Project Name:	Redevelopment of Eldredge Lumber	Project ID:	PL-000148-2018
Address:	165 Presumpscot Street	CBL:	426 A003
Applicant:	BAS Eldredge LLC		425 A015
Planner:	Christian Roadman

On October 2, 2018, the Planning Authority approved a Level II Site Plan application for redevelopment on the Eldredge Lumber site. The decision is based upon the application, documents and plans as submitted. The proposal was reviewed for conformance with the standards of Portland's Site Plan Ordinance.

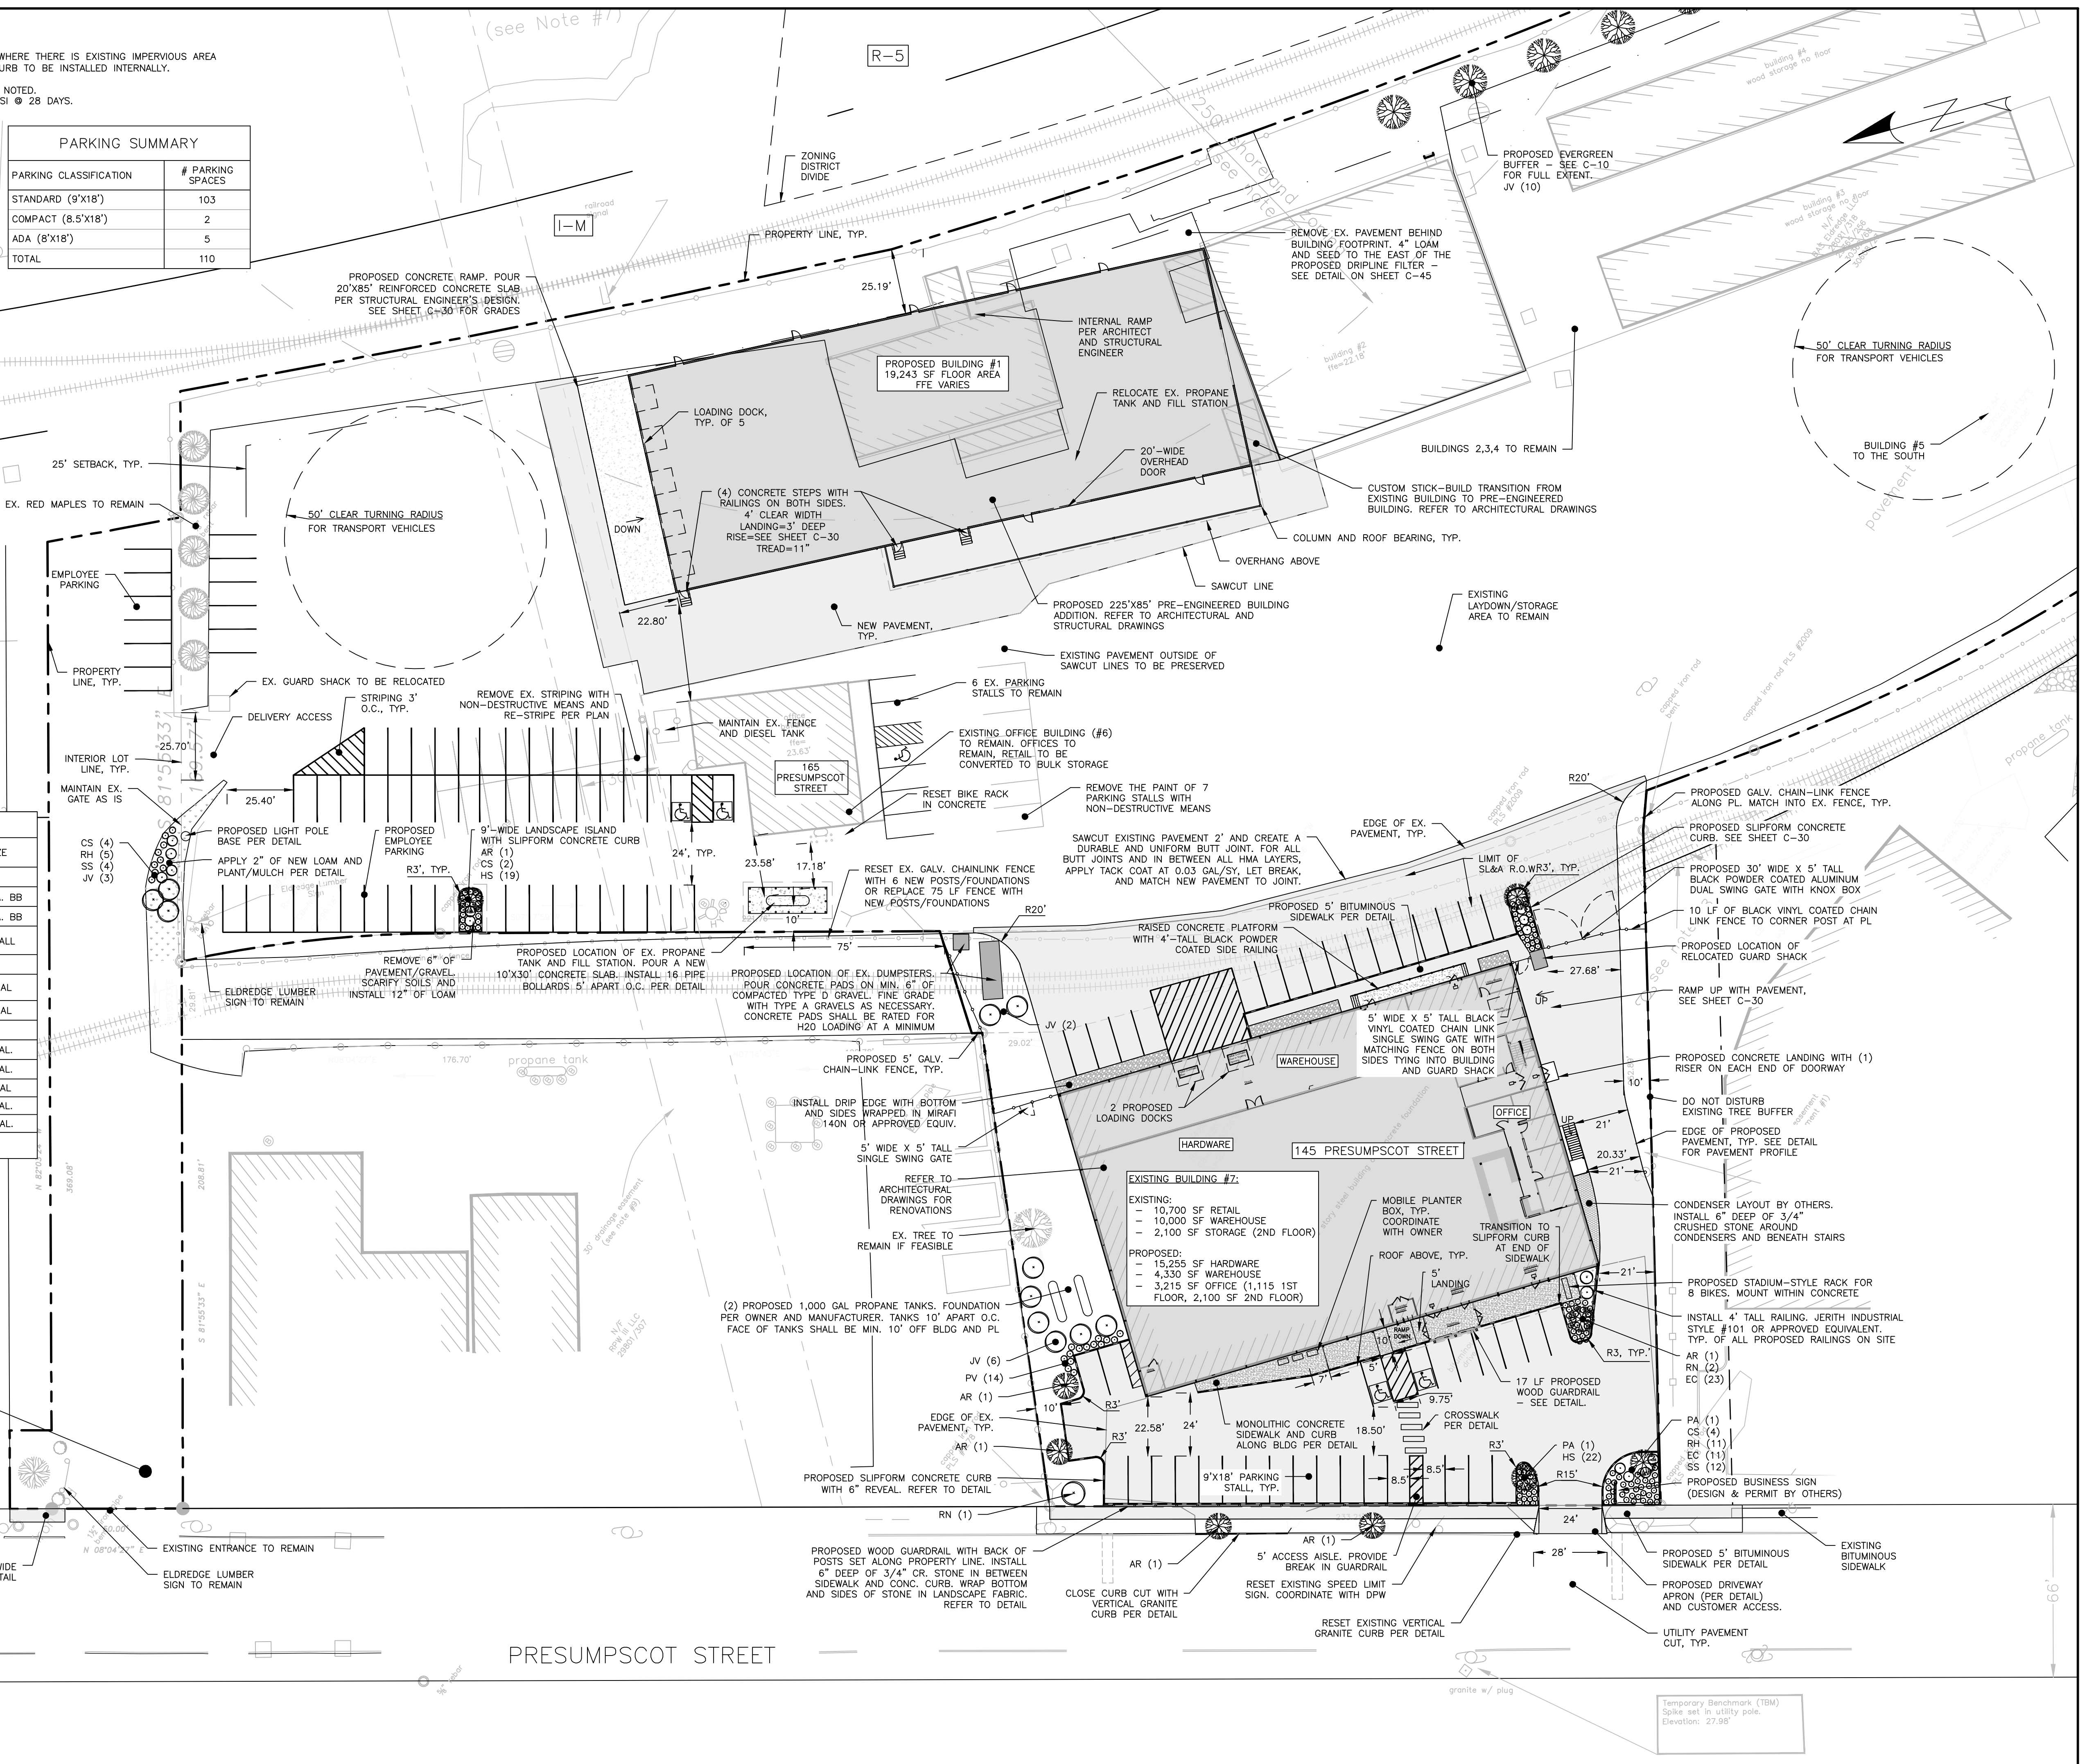
1. The applicant shall furnish a trip generation monitoring study six months after occupancy to determine whether a Traffic Movement Permit is required. The scope and methods of the monitoring study shall be coordinated with City staff.
2. The painted pedestrian walkway shall be widened to 5 feet and the adjacent parking spaces marked as 8.5 feet wide.
3. A Knox Box will be required at the access gate.
